# CITY OF ALBUQUERQUE

September 11, 2013

**Re: Garcias Kitchen Food Prep & Catering  
Grading and Drainage Plan  
Engineer's Stamp Date 8/19/2013 (J13/D096)**

EROSION CONTROL PLAN

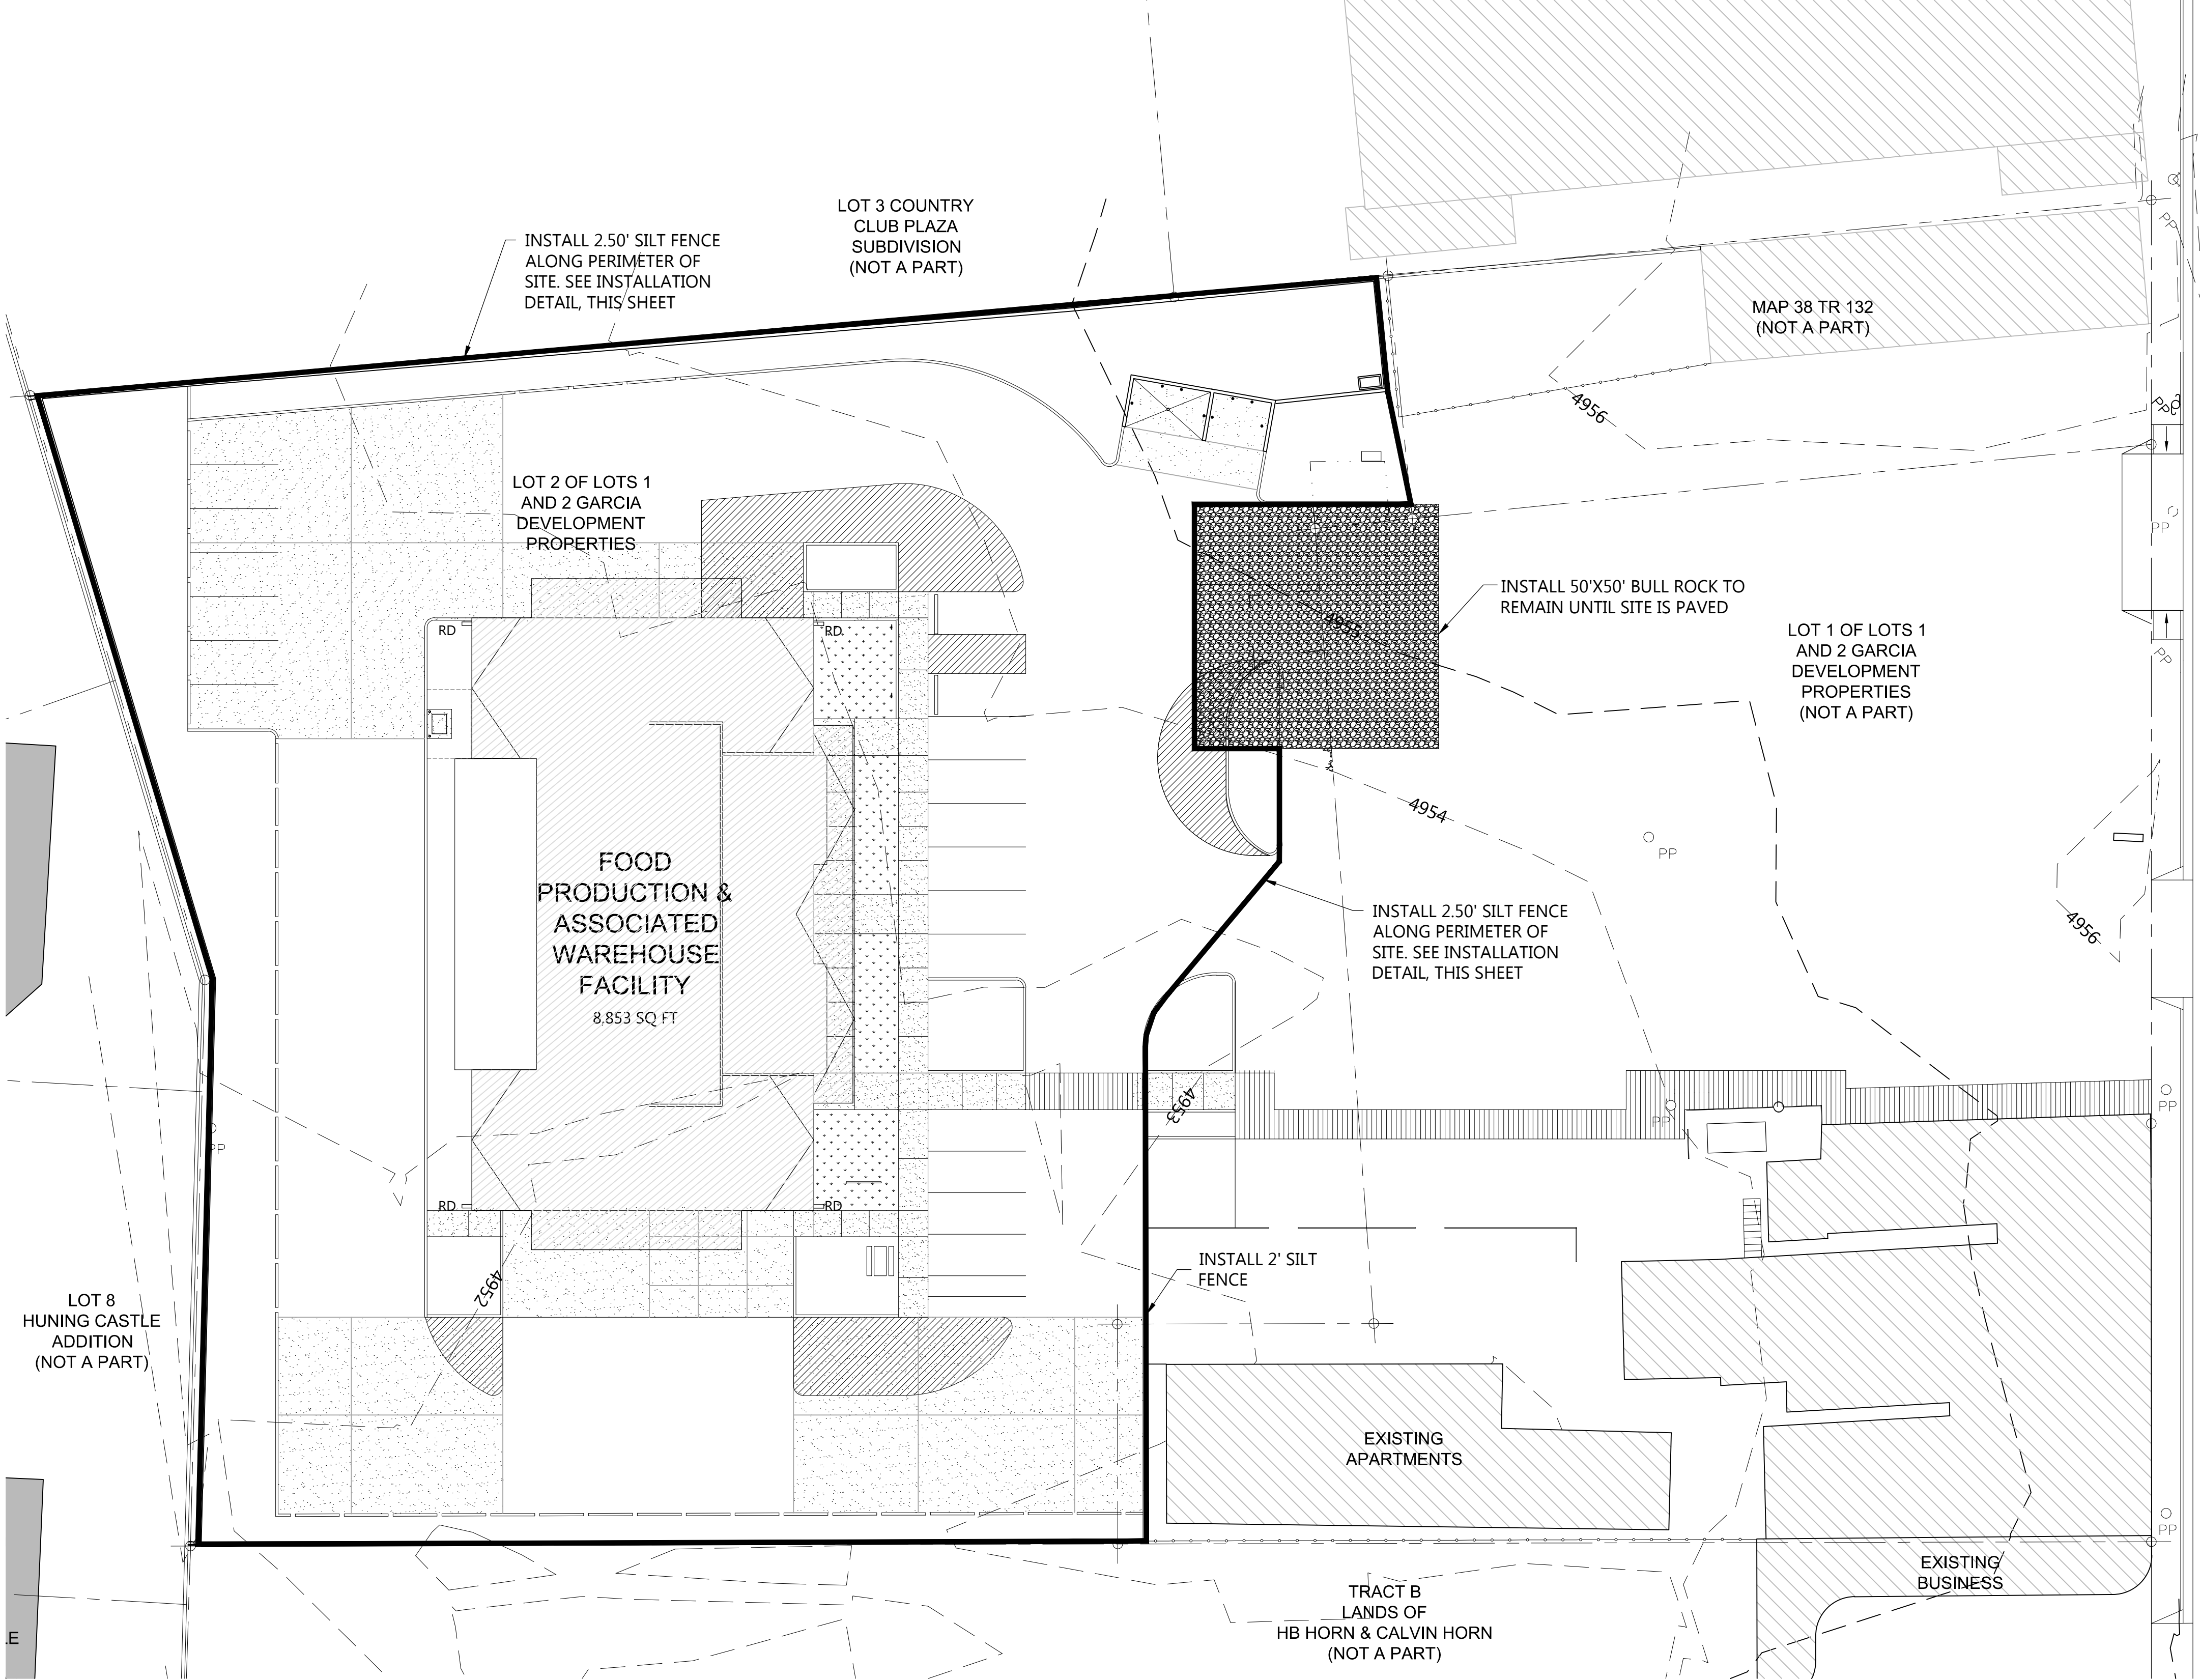
- Erosion Sediment Control Plan and permit must be submitted prior to building permit approval.

GRADING AND DRAINAGE PLAN

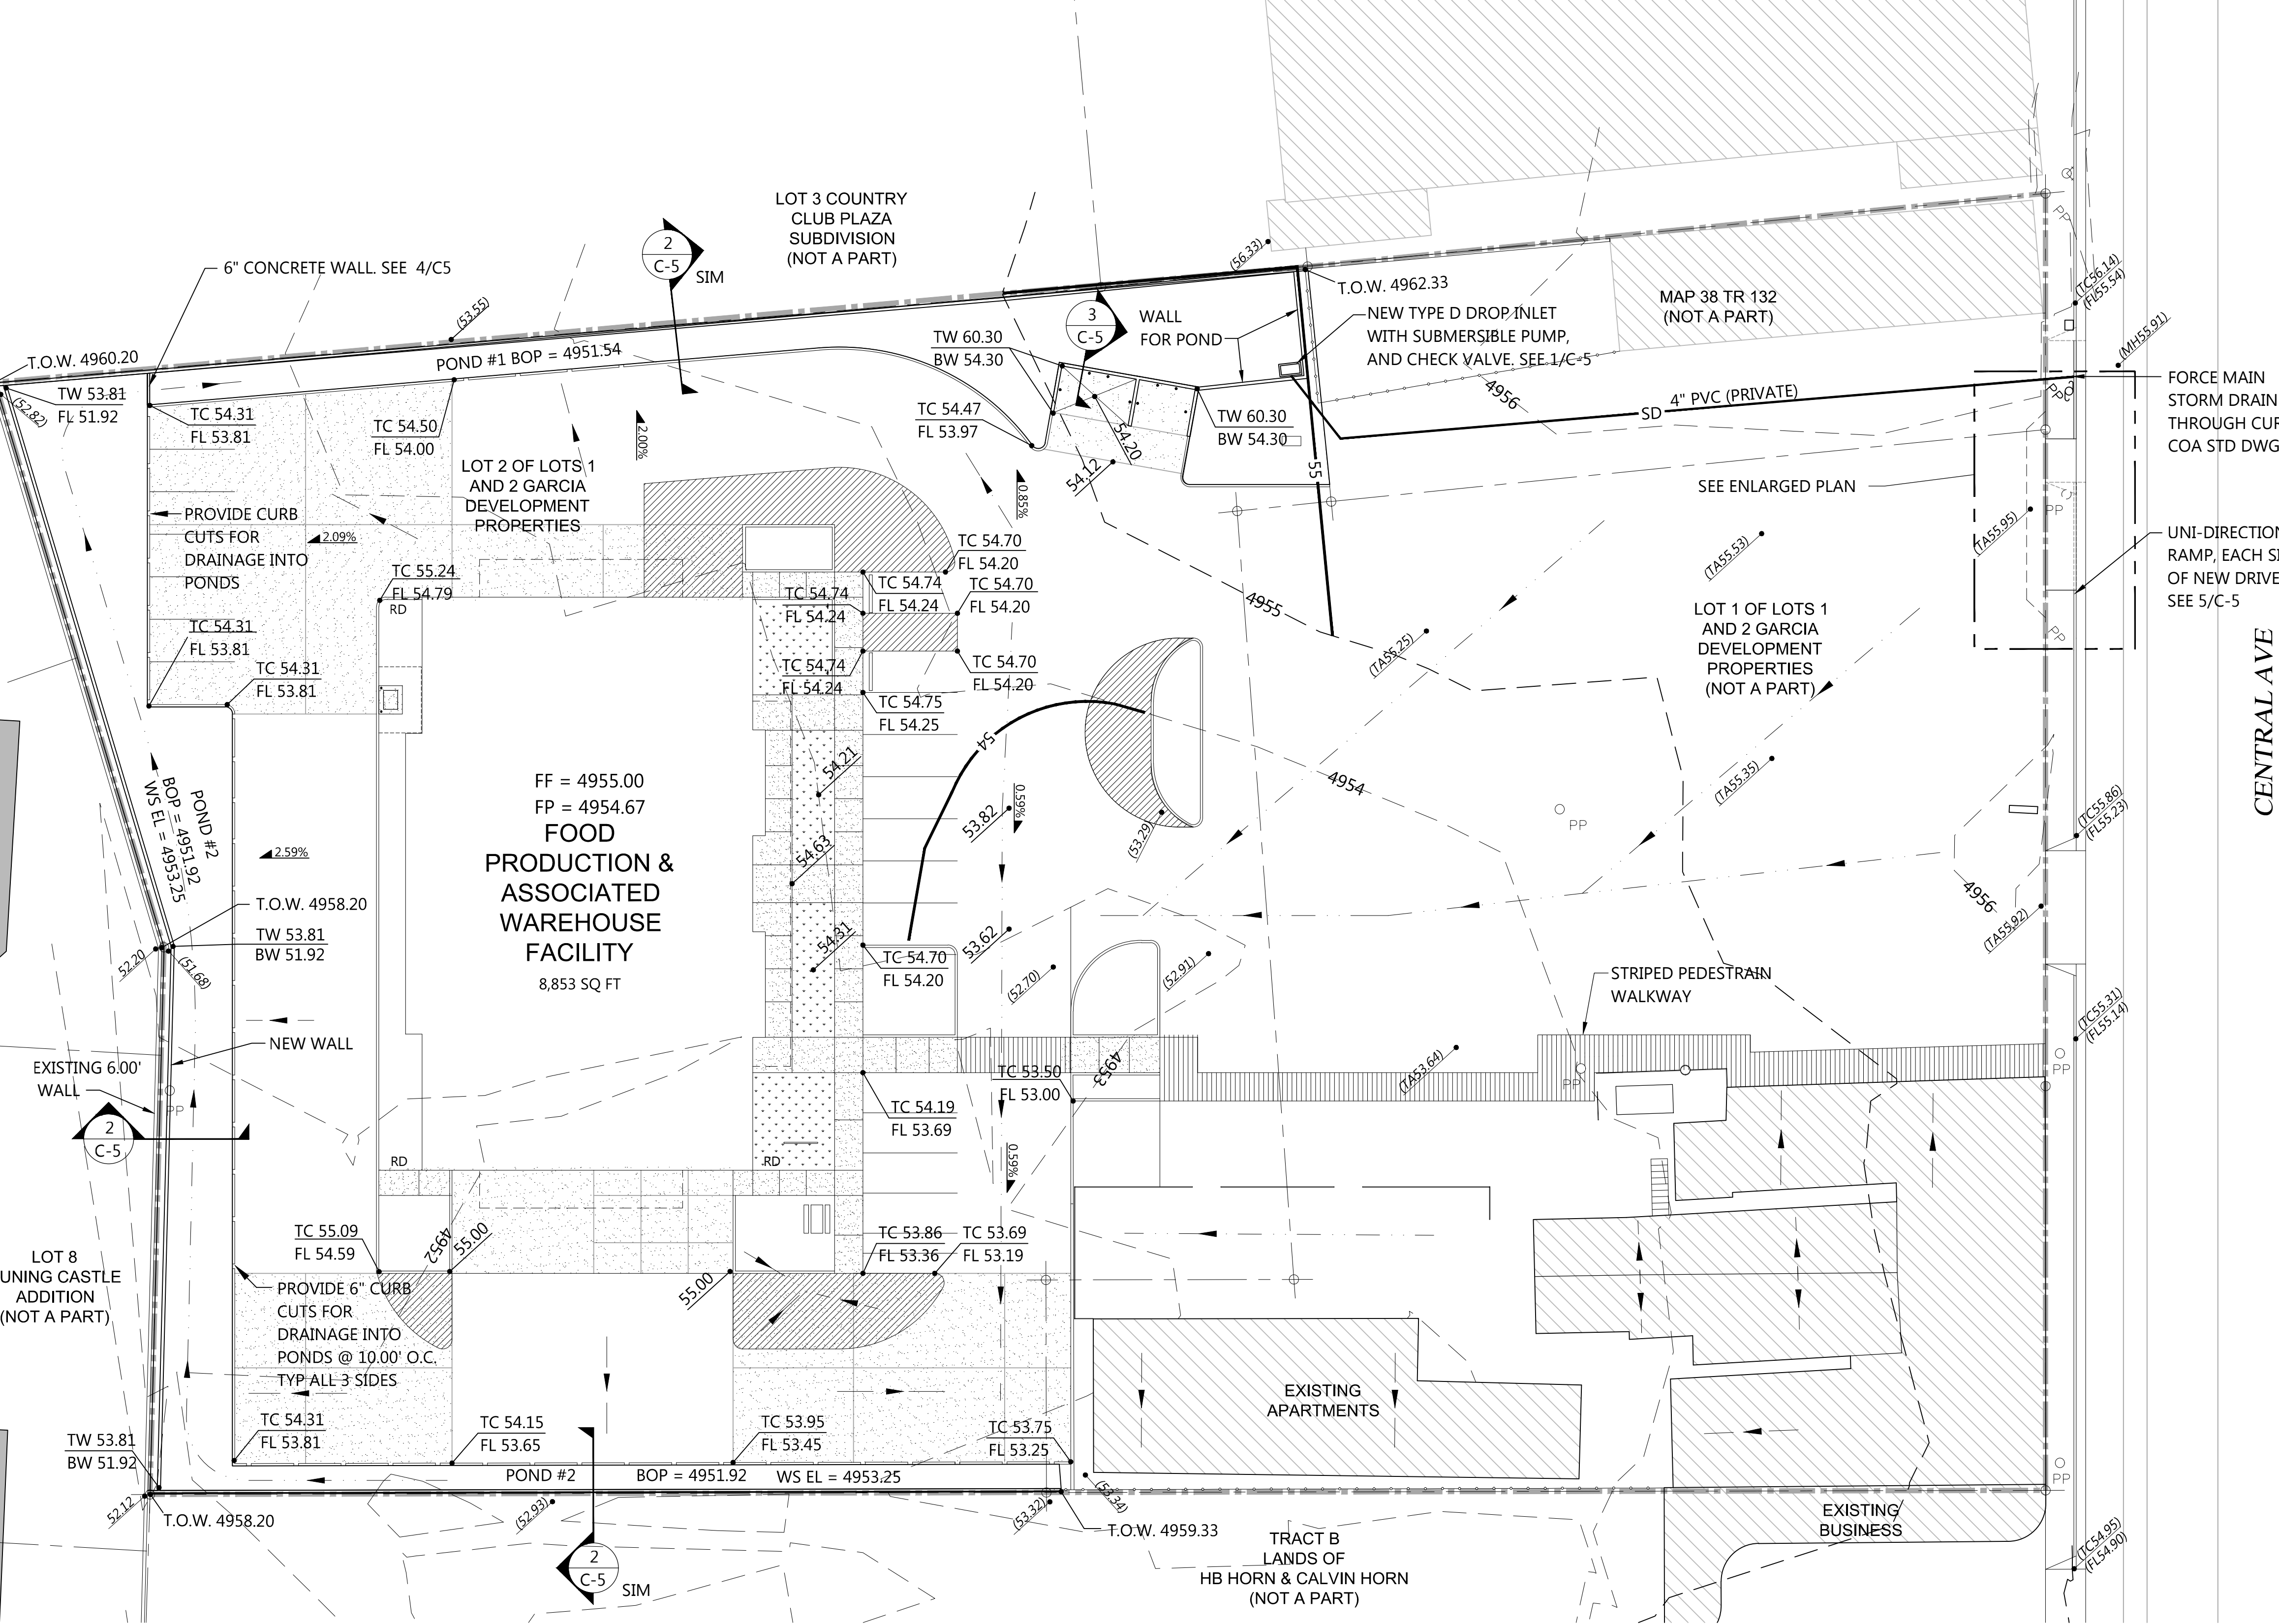
- Please quantify the flows entering from the northwesterly property.
- Clarify existing and proposed spot elevations along the boundary lines.
- Show pond volume calculations. The high water elevation is at 4952.22 and bottom of Pond 1 is at 4952.23. How much runoff is being intercepted by Pond 1?

- Provide 100-yr/10-day Volume calculations and WSEL.
- Please spot elevation for the trash area to assume that the runoff will drain to the center of the enclosure. Please include a note on the grading plan that floor drain will be routed to an oil water separator and then to Sanitary Sewer.

- Provide positive flow away from the building.
- Callout curb opening along the westerly and easterly ponds. Show the curb openings along the easterly pond.
